Re: PA23-005 – Creekside PRD – Technical Review 1
7808 40th Street, 7811 & 7715 40th Street NE, APNs 29050200100200,
29050200100300, and 29050200100400

BINDING SITE PLAN / PLANNED RESIDENTIAL DEVELOPMENT COMMENTS

SHEET NO:  
**L-1**  
OF 6

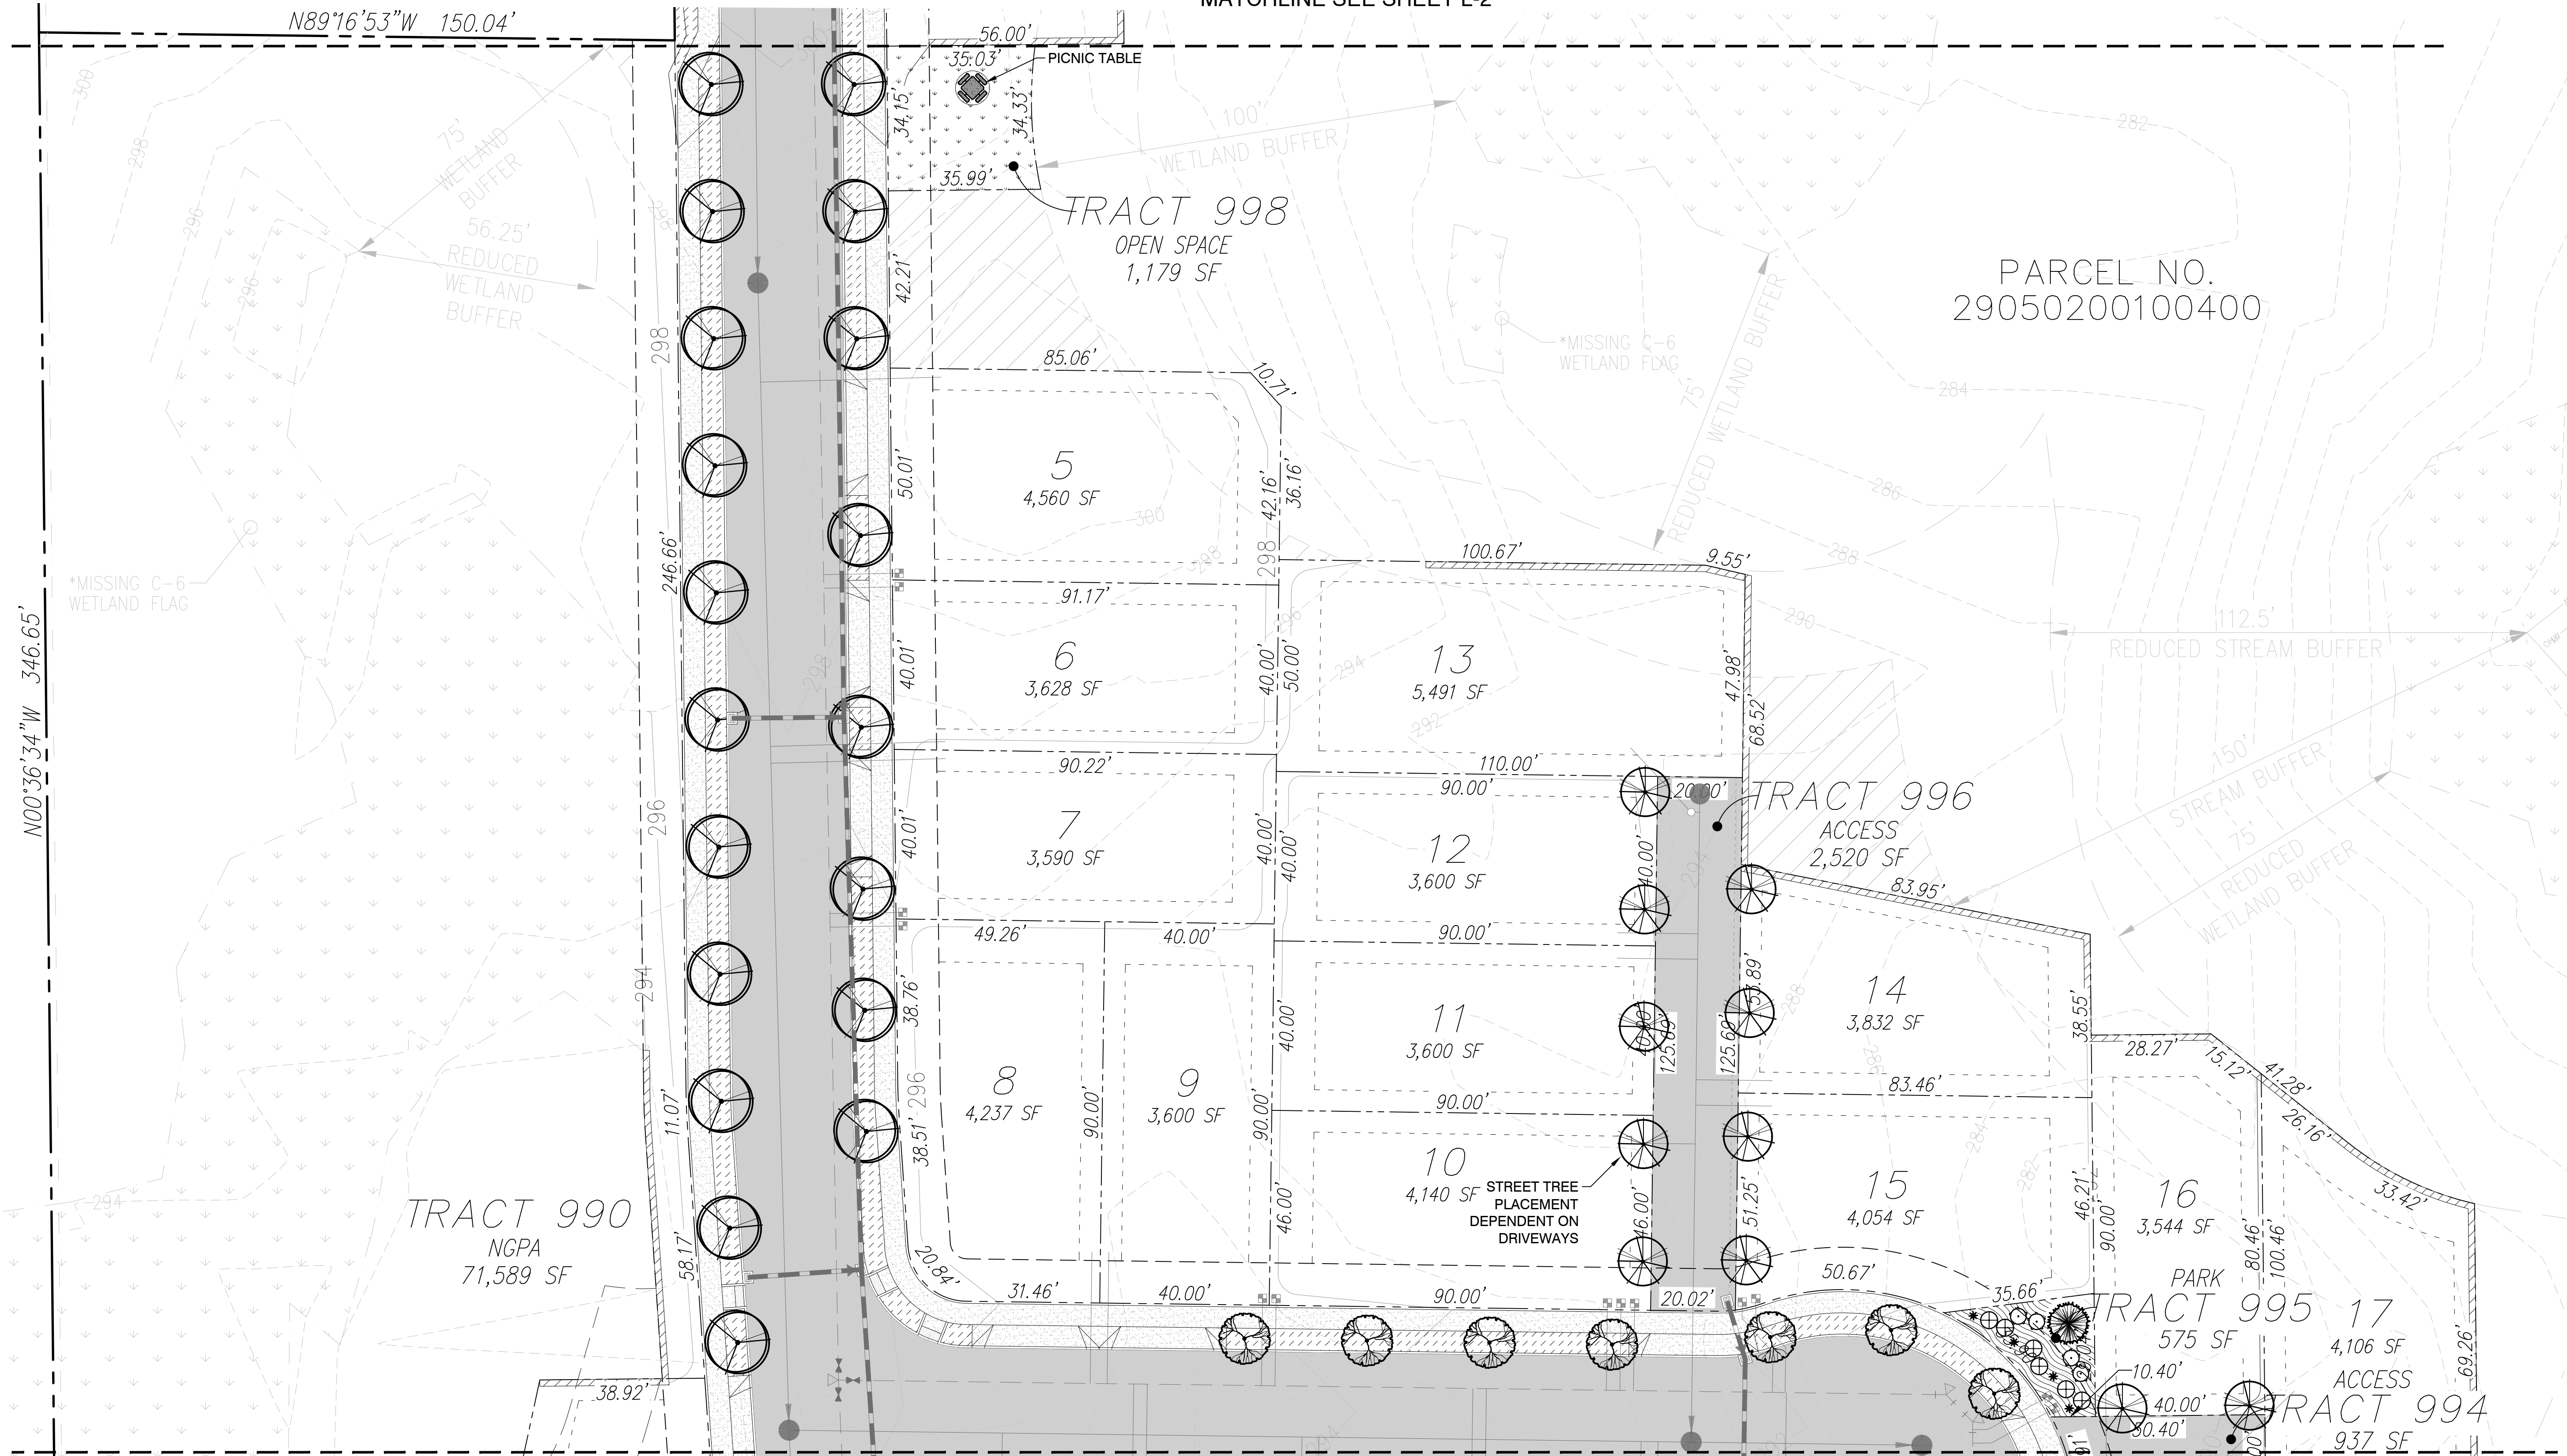
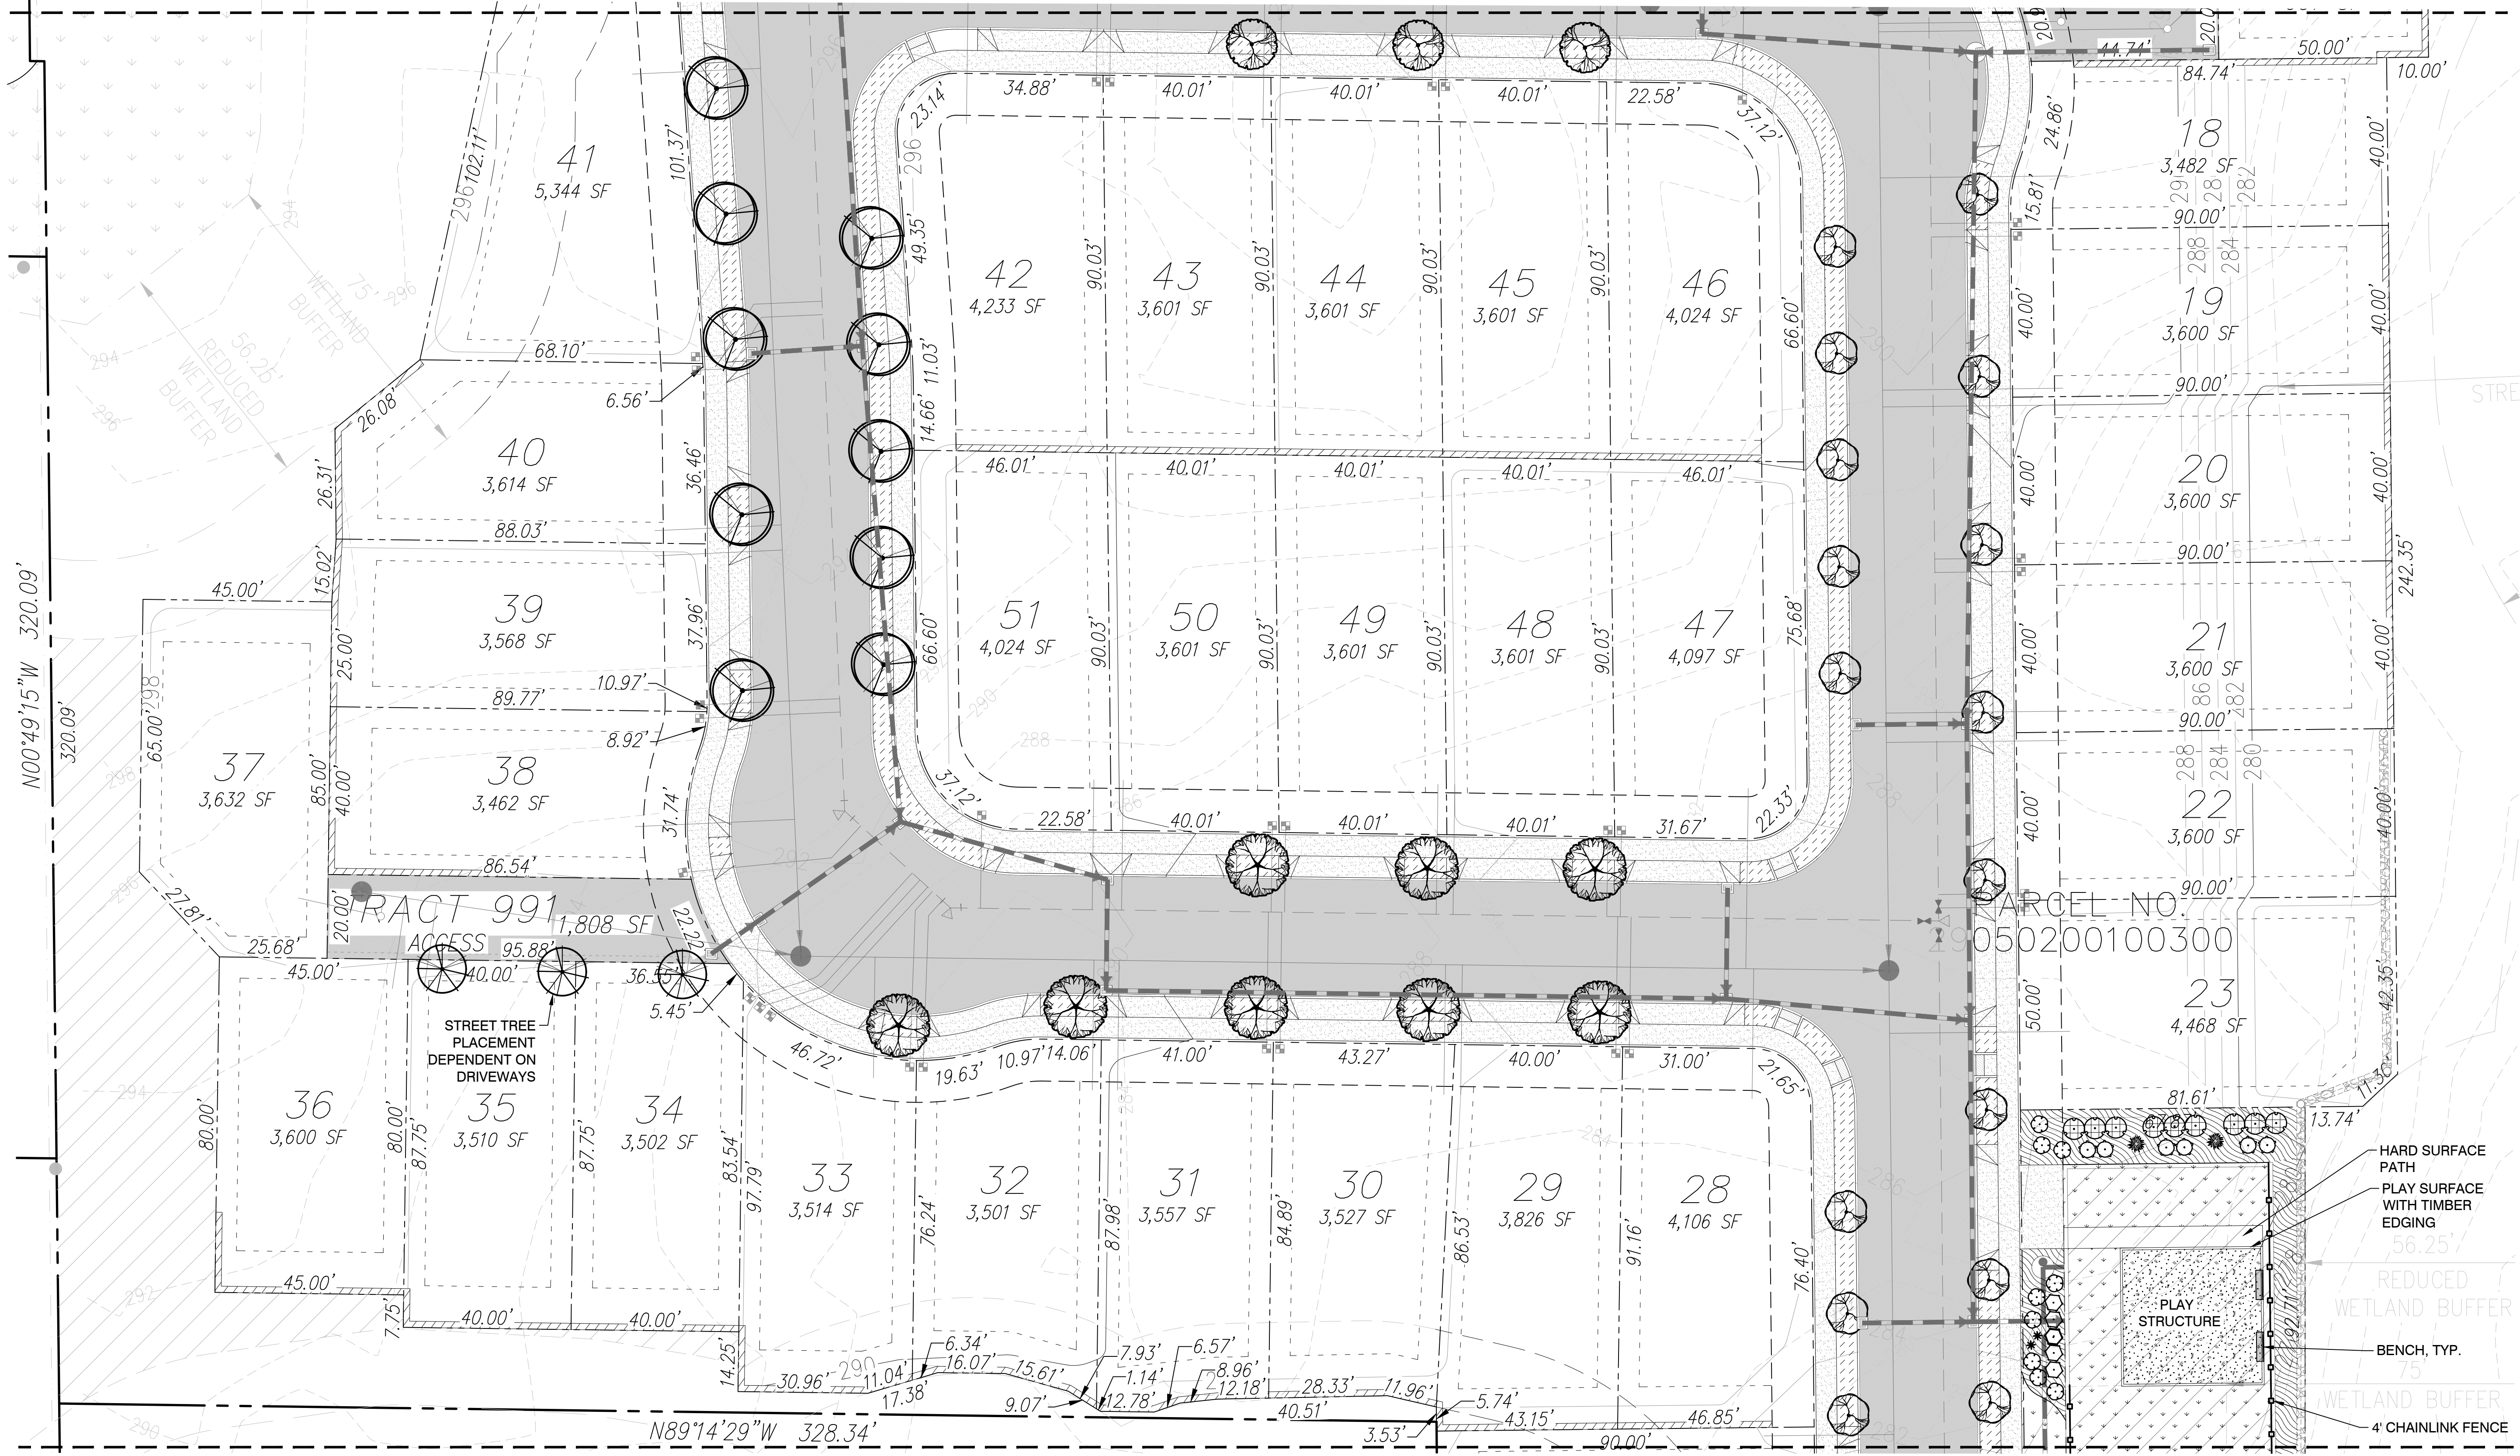
18. Chain link fences are not permitted within the East Sunnyside Whiskey Ridge subarea. Please amend the site plan to include this prohibition. Please revise the landscape plan to incorporate and different type of fencing.
19. The vault in tract 993 shall comply with the 15' setback (see comment 13.1 above).

20. A final landscape plan shall be required to be approved, prior to civil construction plan approval, and designed to comply with the applicable provisions outlined in [MMC Chapter 22C.120, Landscaping and Screening](#). **Specifically, please revise the Landscaping Plan to include:**

20.1. Typical side view of perimeter landscape areas, specifically the proposed 10 ft. landscape easements.

20.2. Perimeter plantings for open space tracts.
